Rezoning Transportation Analysis

Petition Number: #2022-089

From: Jake Carpenter, PE

Date	Description
11-28-22	First Review (TM)

RZP-2022-089

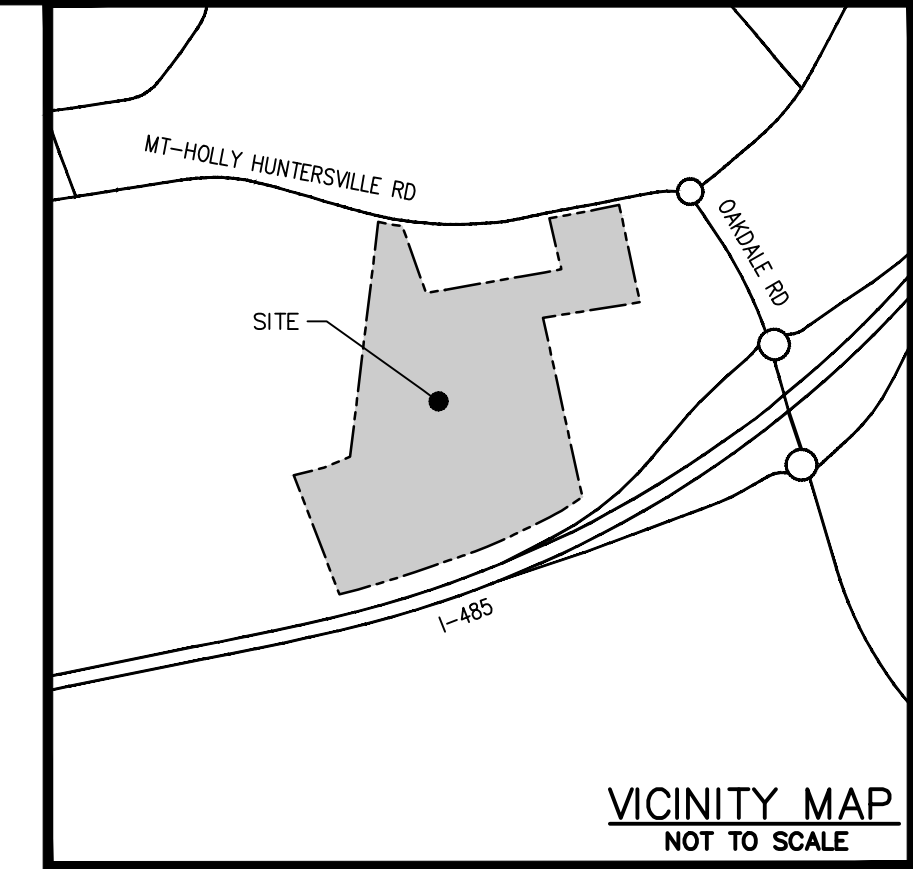
Label and dimension the curb and gutter from the centerline for each road on the site plan.

3. Revise site plan and conditional note(s) to commit to dedicate 50-feet of right-of-way from the road centerline. The site plan shall label and dimension the right-of-way from the road centerline.

4. Revise site plan and conditional note(s) to commit to construct an 8-foot planting strip, and 12-foot multi-use path on Mt Holly-Huntersville Road per Chapter 19. The site plan shall label and dimension both items from the back of curb and gutter and road centerline.

6. Site plan and conditional note(s) revisions are needed to commit to construct bicycle facilities by locating the curb and gutter 30-feet from the center line and installing a 12' multi-use path on Mt Holly-Huntersville Road to meet the City Charlotte BIKE Policy.

7. Site plan and conditional note(s) revisions are needed to commit private street A,B & C as public roadways. Public street C to stub to the western property line for a future roadway connection. The public roadways are to be designed to CLDSM standards U-03 to accommodate on-street parking. The Right-of-way, curb line and sidewalk are to be dimensioned from the roadway centerline. Add a conditional note committing to the construction of each public roadway.

8. Site plan and conditional note(s) revisions are needed to label roadway "B" site access as right-in right-out and roadway "A" site access as full movement. A right-turn lane is required at site access B, site plan shall label and dimension turn lane. A right-turn lane and left-turn lane is required at site access A, site plan shall label and dimension turn lane.

12. Revise site plan to construct a 12-foot multi-use paths on Mt Holly Huntersville Road. The site plan shall label and dimension both items from the back of curb and gutter and road centerline. The entire facility must be outside of the right of way and within a public access easement. Add conditional note committing to construction and maintenance of the 12-foot multi-use paths on Mt Holly Huntersville Road.
